Response to Submissions Bobs Farm Sand Mine Project (SSD 6395)

Attachment A

Figure 2: Noise Sensitive Receivers (R1 & R8 - R19) and Noise Monitoring Locations (N3 – N4)

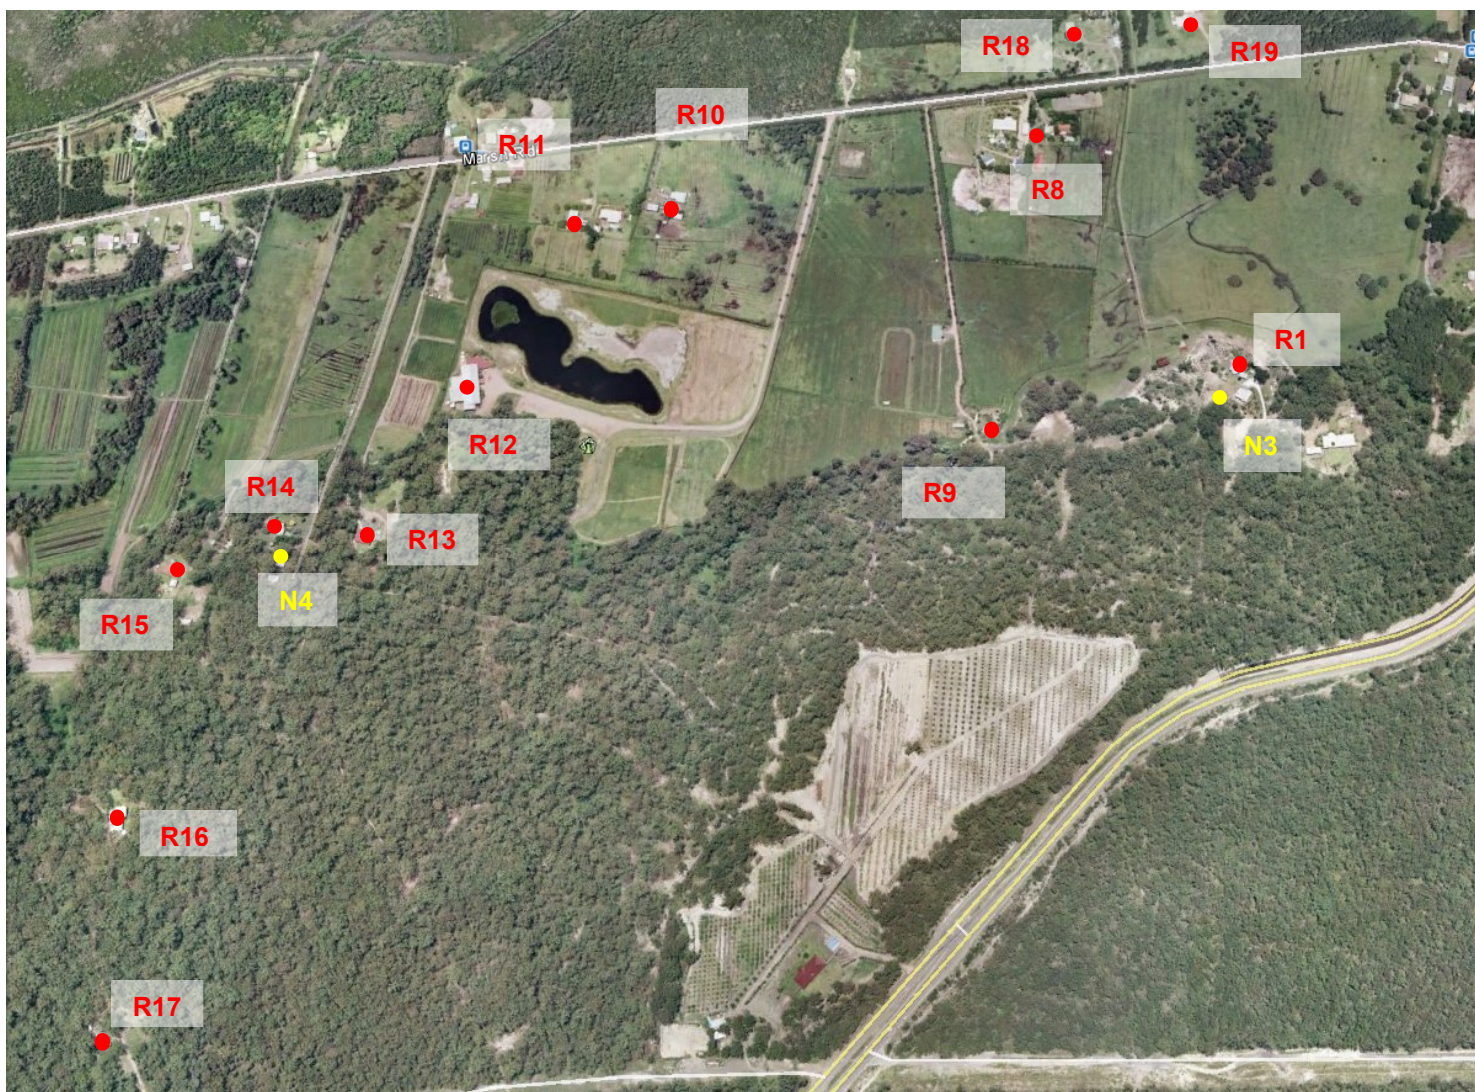
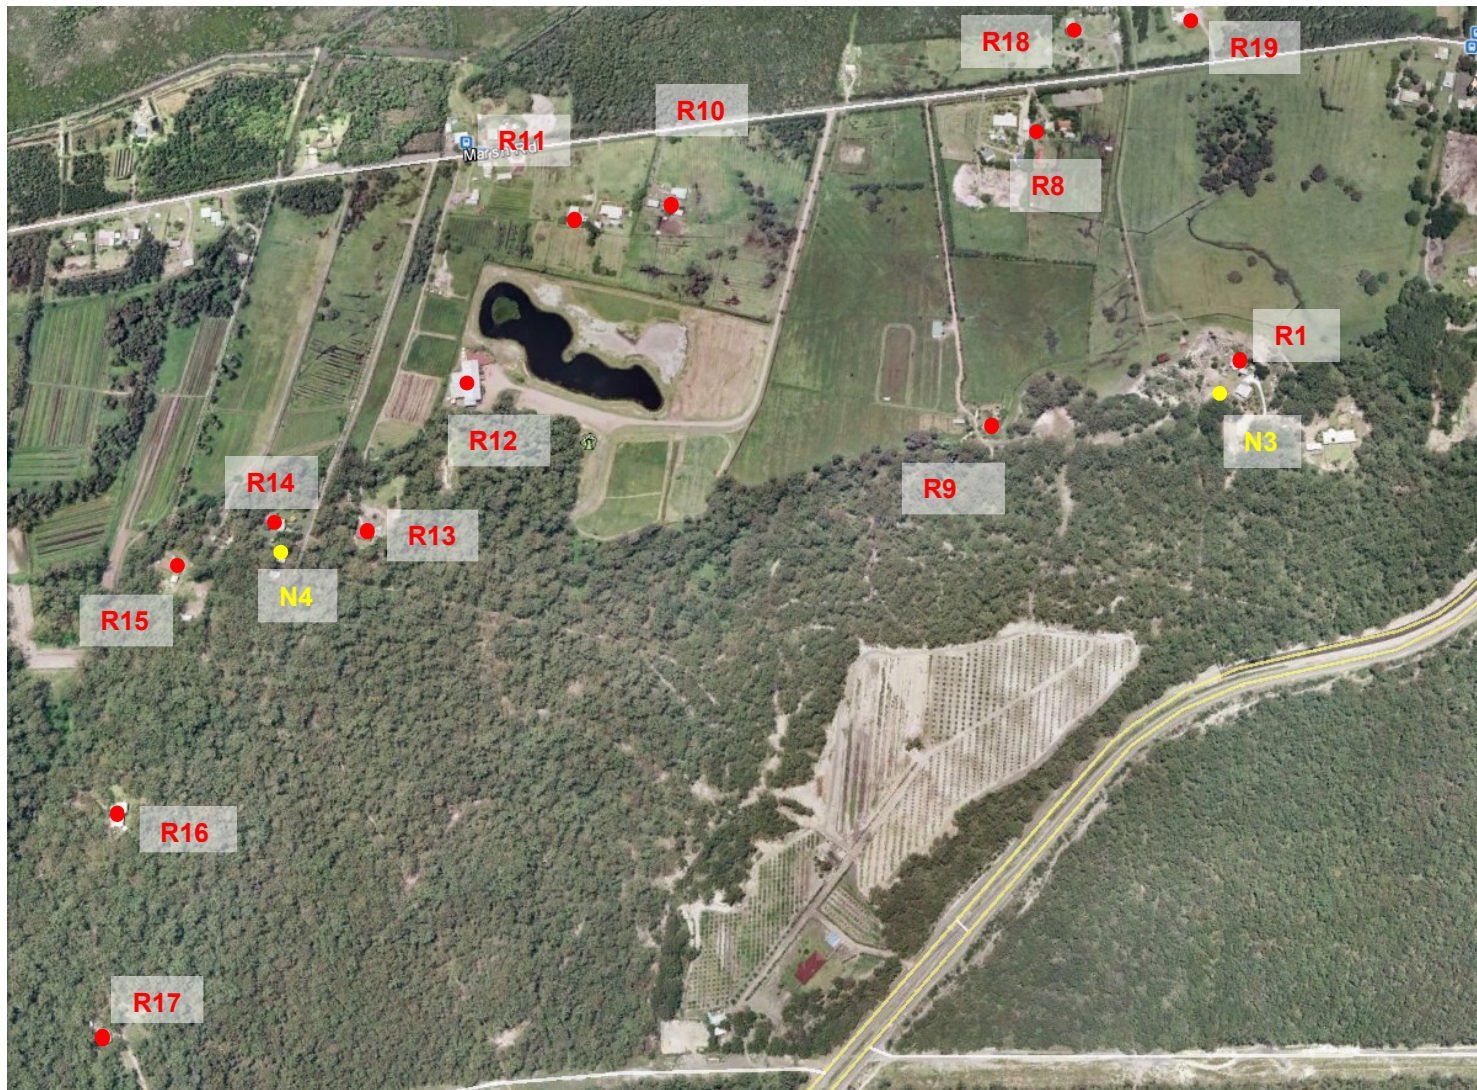
- Table 4 of the NIA states that noise was monitored at site N3 for the period 12-18 August 2014. Please resolve the inconsistency with the graphical information which is provided for the period 16-24 August 2014.

- Table 4 of the NIA states that noise was monitored at site N4 for the period 12-18 August 2014. Please resolve the inconsistency with the graphical information that is provided from 1600 hours on 02 September 2014 until 2400 hours on 04 September 2014.

Figure 3: Noise Sensitive Receivers R2-R7 & R20-R25 & Noise Monitoring Locations N1 & N2

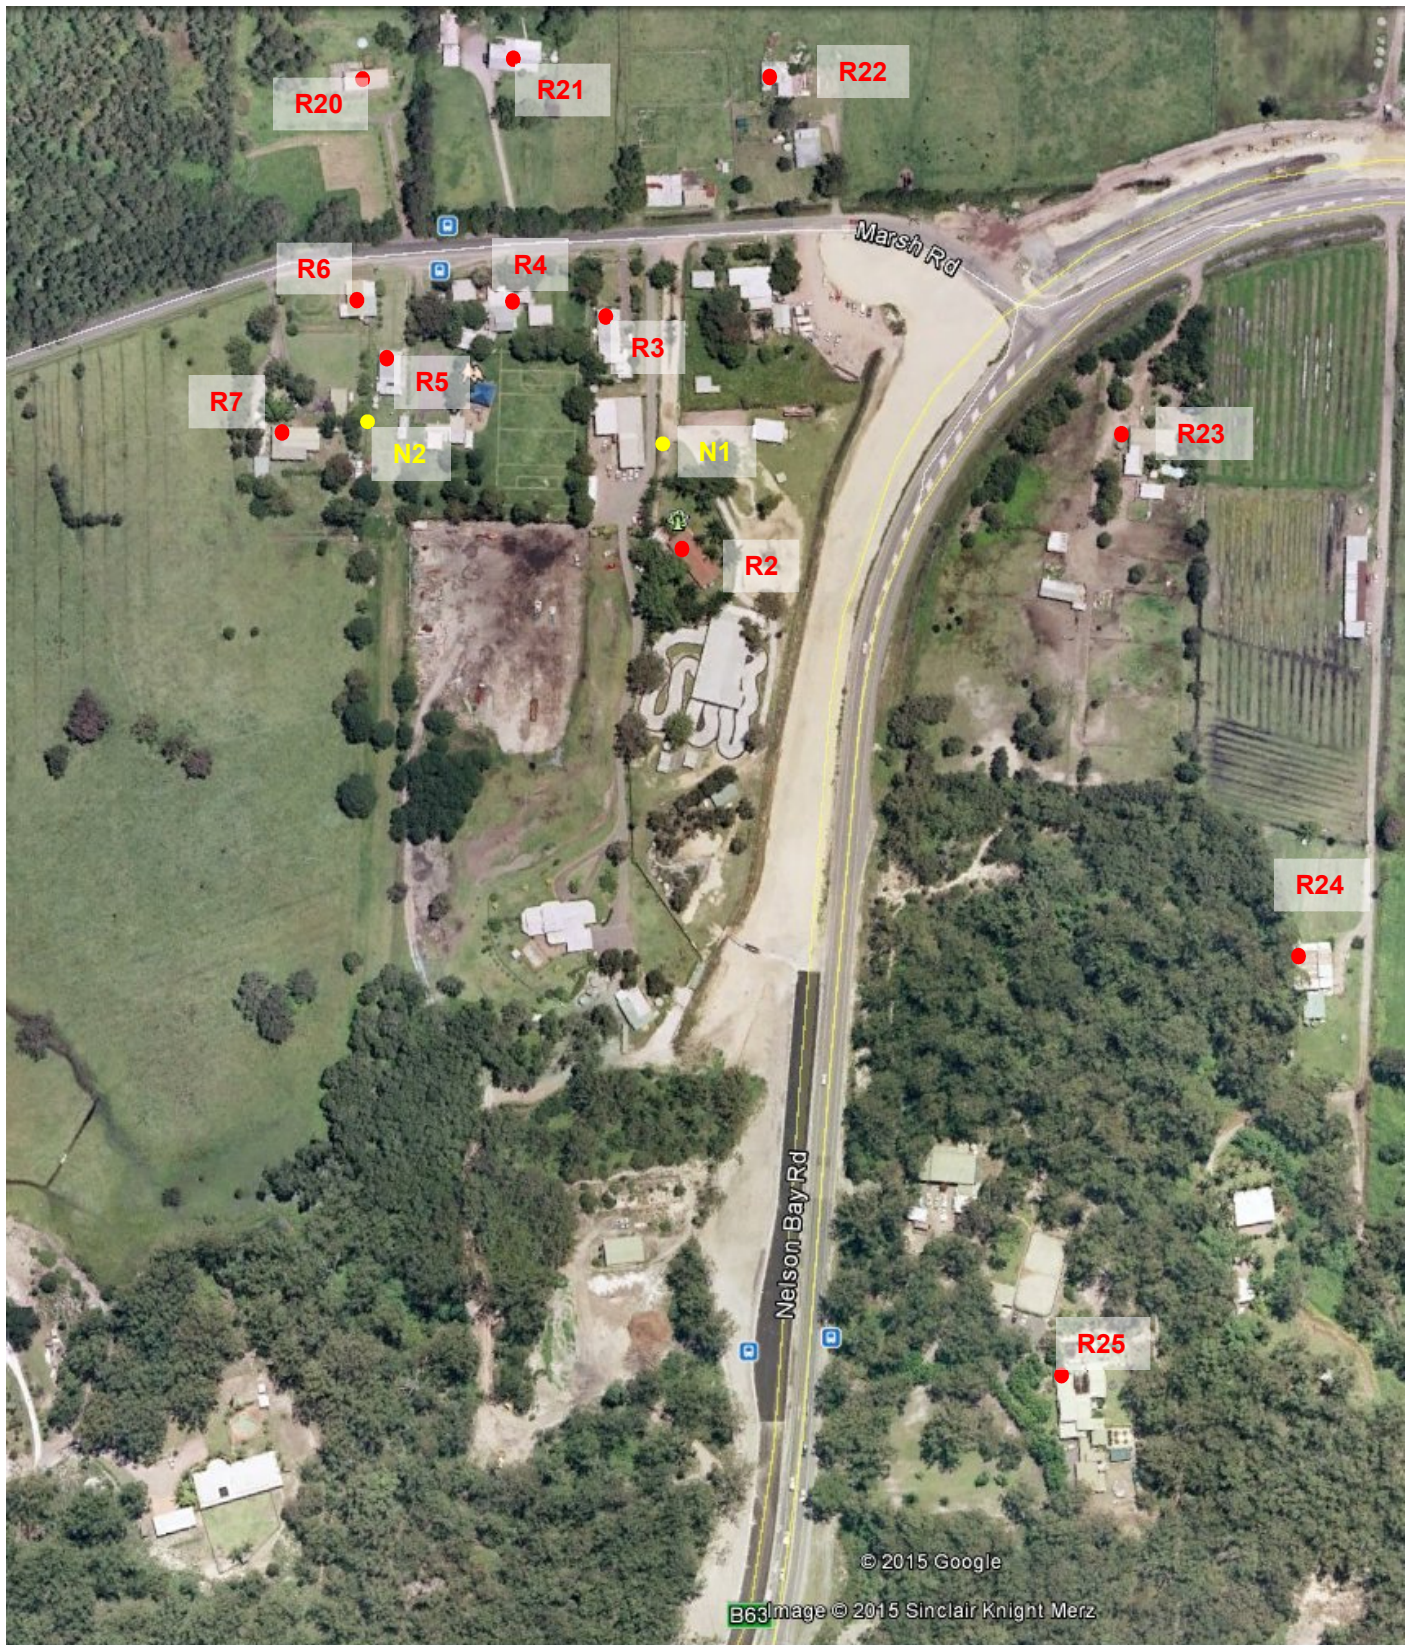
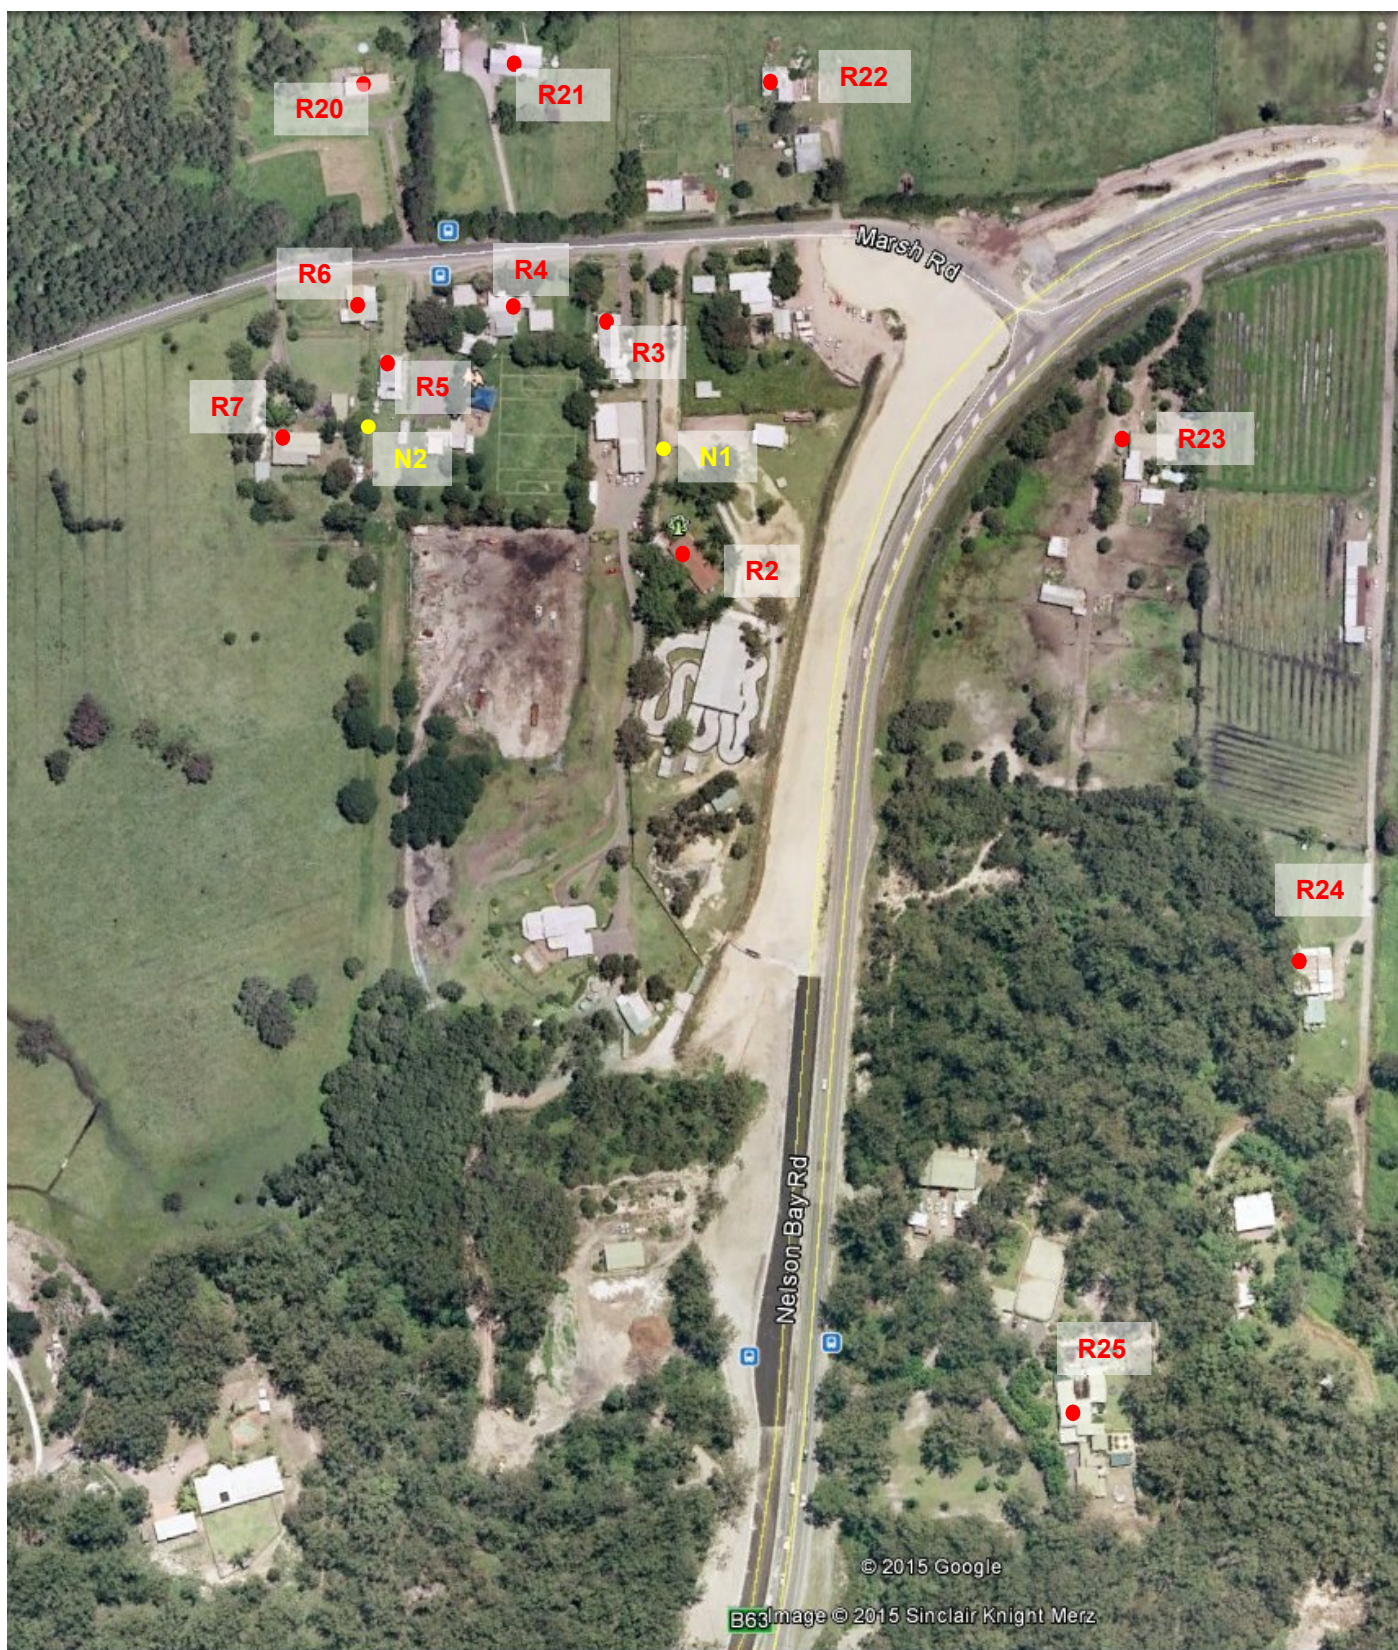
- Table 4 of the NIA states that noise was monitored at site N1 for the period 02-06/09/2014. Please resolve this inconsistency with the graphical information which is provided from 1600 hours on 02 September 2014 until 2400 hours on 04 September 2014.

- Table 4 of the NIA states that noise was monitored at site N2 for the period 12-18 August 2014. Please resolve this inconsistency with the graphical information which is provided for the period 16-25 August 2014.

- Table 5 of the NIA presents the outcome of background noise monitoring for sites N1 to N4. Please provide an explanation for the difference of 9dB(A) between sites N1 and 2 for Day time RBLs, when they are separated by only 125 metres. What influence did the Go Kart track at 75 metres from site N1 have on the background noise recorded? Similarly, what influence did the location of Nelson Bay Road at 85 metres from site N1 have on the background noise recorded?

Figure 3: Proposed Mine Design and Configuration

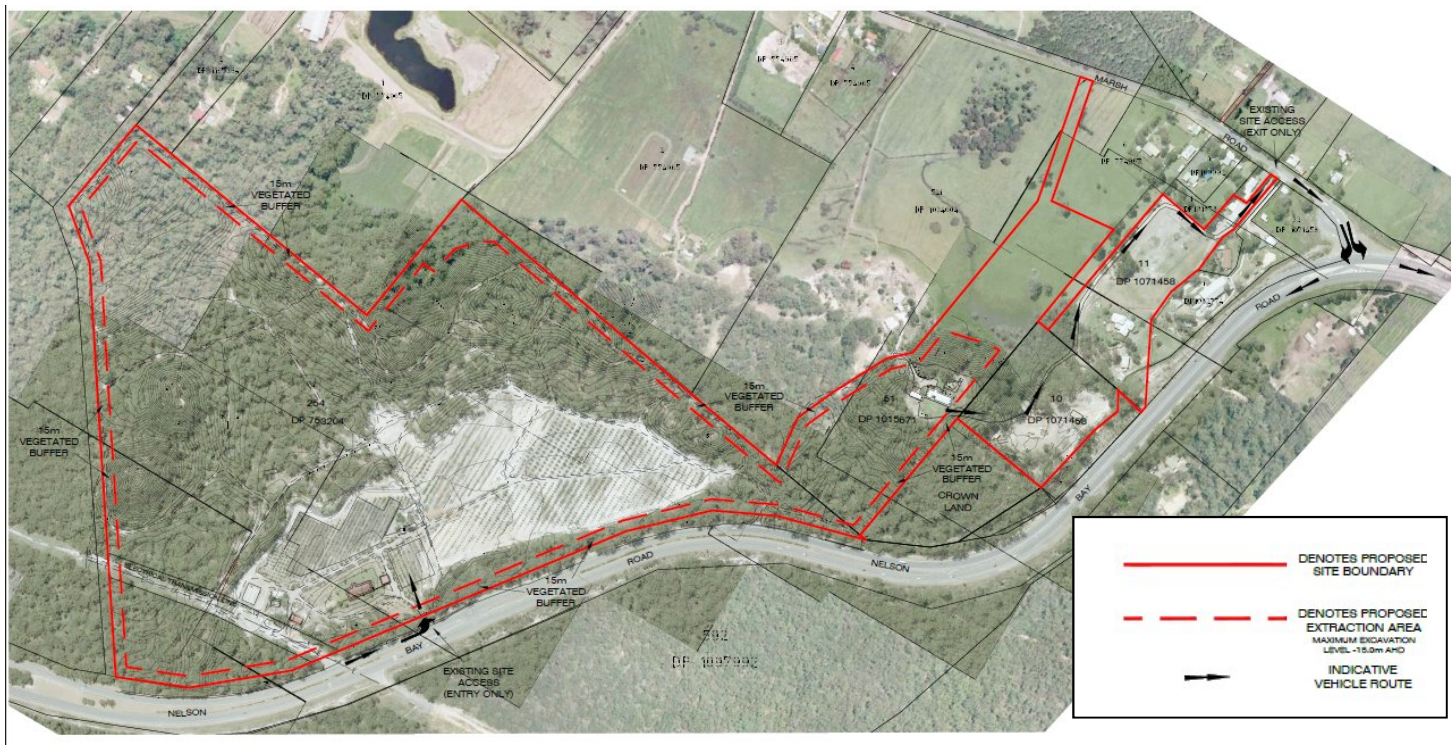
- Figure 11.1 on page 364 of the EIS showing the "Site location – Deposited Plans" that differs from the layout shown in Annex T;
- Figure 11.3 on page 367 of the EIS showing the "Proposed Mine Design and Configuration" that differs from the layout shown in Annex T;
